From: Jamie Brown [REDACTED]
Sent: 15 August 2018 14:34
To: Anita Gardner
Subject: RE: EG/52/18/DOC

From: Anita Gardner [<mailto:Anita.Gardner@arun.gov.uk>]
Sent: 15 August 2018 12:40
To: Jamie Brown
Subject: EG/52/18/DOC

I have received a Discharge of Condition application relating to the provision of a bound material at the site entrance as requested in your consultation response(attached). Is there a minimum suggested width? The applicant is proposing 6 inch timber edge along the road frontage. Would this be wide enough?

Stoneyfield Nursery new drive.
Detail of junction to Eastergate Lane
Ref; EG/22/17/PL

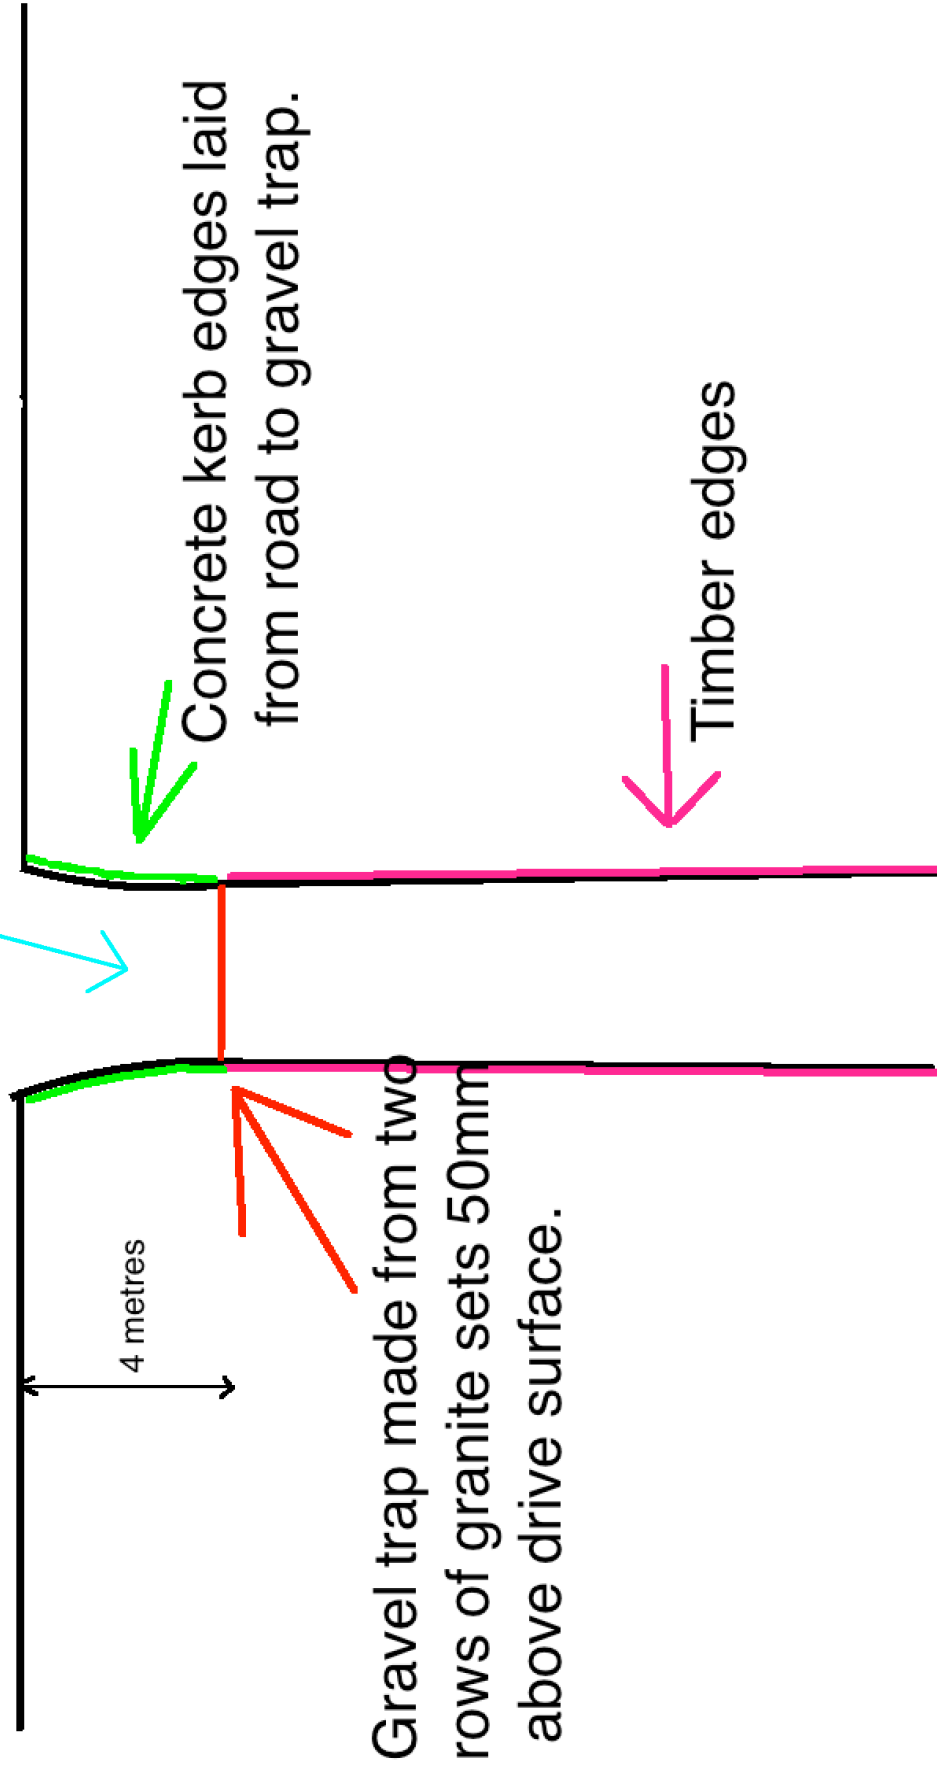
Yes that could work. I would need to get them to demonstrate it on a plan if possible.
